KITITAS COUNTY

MEMORANDUM

TO: All Staff
FROM: Public Works Plan Review Team
DATE: November 17, 2025- UPDATE January 26, 2026
SUBJECT: BL-25-00019 M&M Lowe Family LLC.

WPA ROAD

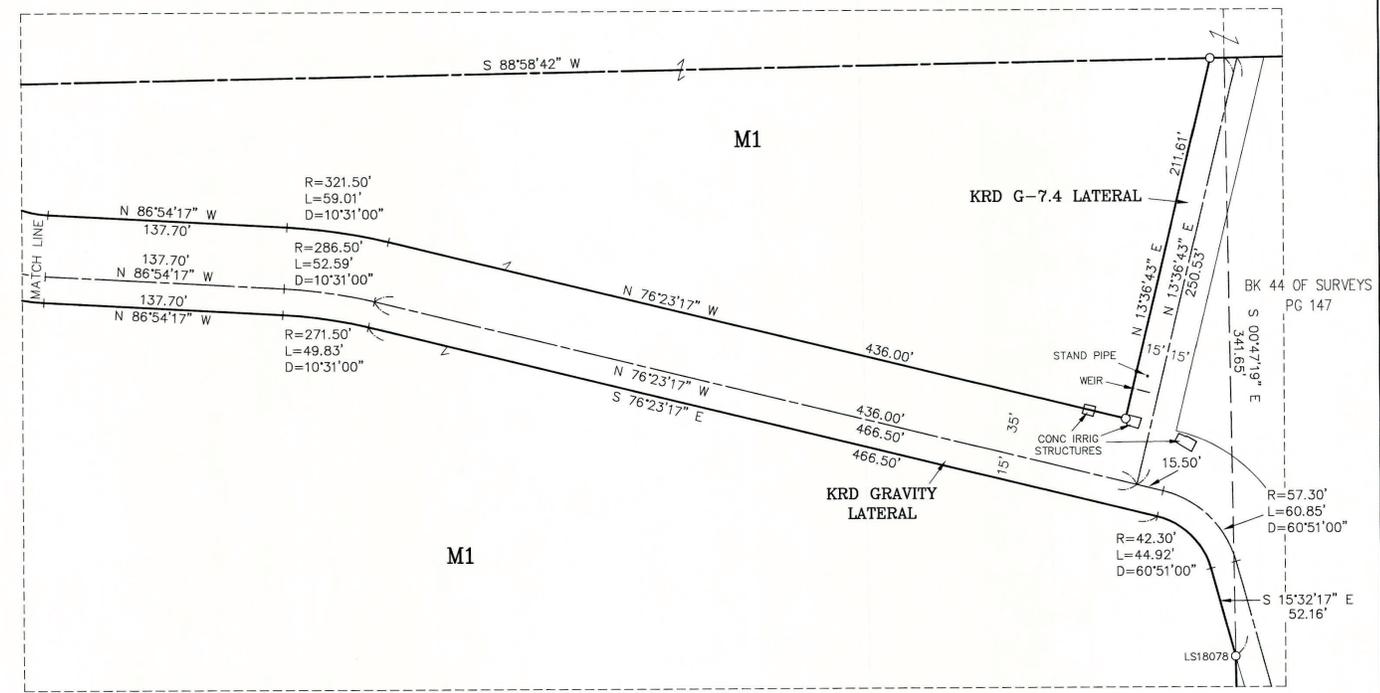
<p>2. Please label WPA Road as a county road.</p> <p>3. Per available aerial imagery, there are structures located South of the KRD Turbine Lateral near the East line of Parcel M1 and near the West line of Parcel M1. These should be shown on the map, or confirmation that these have been removed.</p> <p>4. Sheet 7 contains dimensions that may be unclear after scanning, due to touching property corner symbols. (3 occurrences).</p> <p>UPDATE 1/26/2026 No Further Comments. DF</p>
TRANSPORTATION CONCURRENCY	<p>Updated 11/20/2025</p> <p>Of Note: No transportation management application will be required of project as presented. Future development may be subject to concurrency requirements. (KAH)</p> <p>A concurrency evaluation and determination shall be required for all development applications in which the proposed development is projected to have an impact upon the transportation corridor or intersection. Developments generating 41 or fewer daily trips are exempt from the TIA and concurrency evaluation requirements. (KAH)</p>
